## KITTTITAS COUNTY COMMUNITY DEVELOPMENT SERVICES

**RE: DCCDLC Short Plat (SP-06-64)**

The Kittitas County Community Development Services Department has determined that the DCCDLC Short Plat is a complete application and hereby grants **conditional** preliminary approval subject to the following conditions:

DCCDLC SHORT PLAT

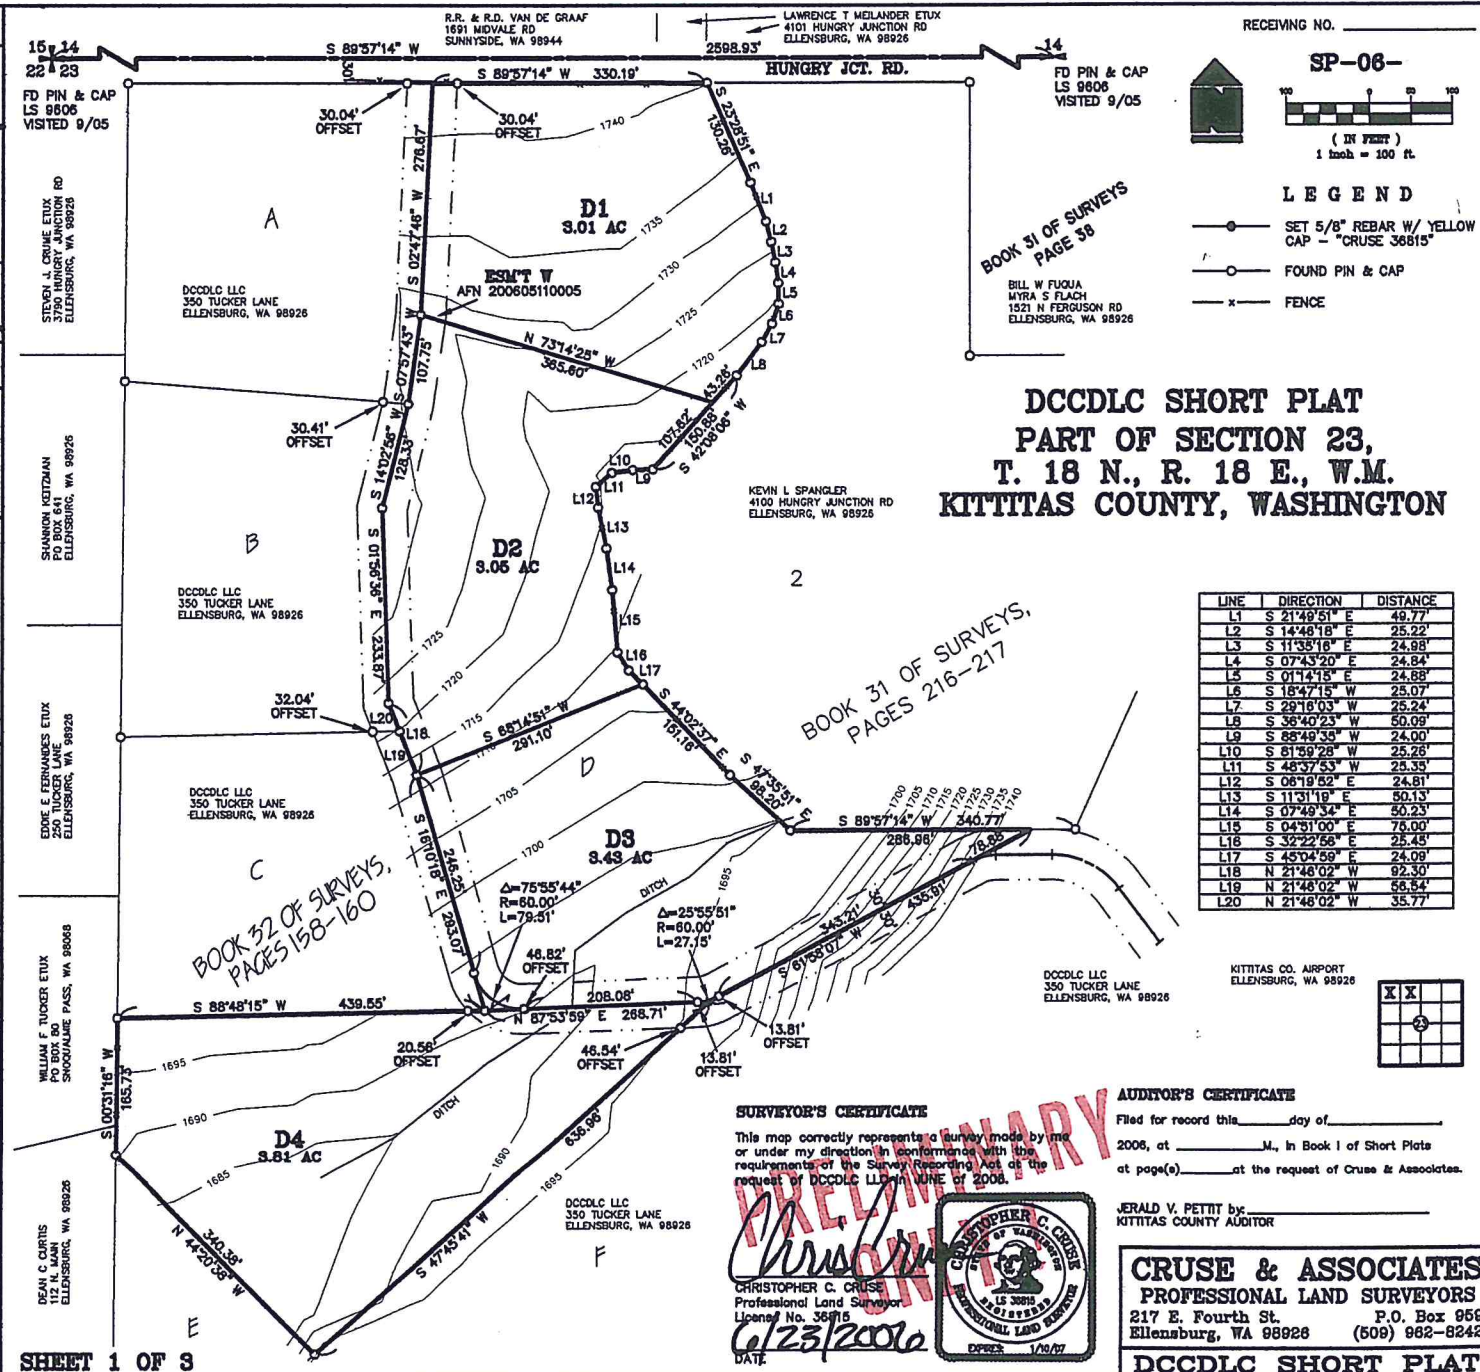
1. Both sheets shall reflect the short plat number SP-06-64.
2. The continuation of the ditch exiting lot D4 must be shown on the final mylar.
3. There is a PEMC wetland on lots D3 & D4. This must be shown on the final mylar. Please see attached map for further information regarding the location of said wetland.
4. A notice from KRD approving an irrigation plan must be received in the CDS office prior to final plat approval.
5. Please contact Randy Carbary at 962-7019, Kittitas County Public Works, regarding all road standards and access questions.
6. Attached you will find comments from Kittitas County Environmental Health. **Please see those documents for required plat notes and information on issues needing completion before final approval of this short plat.**
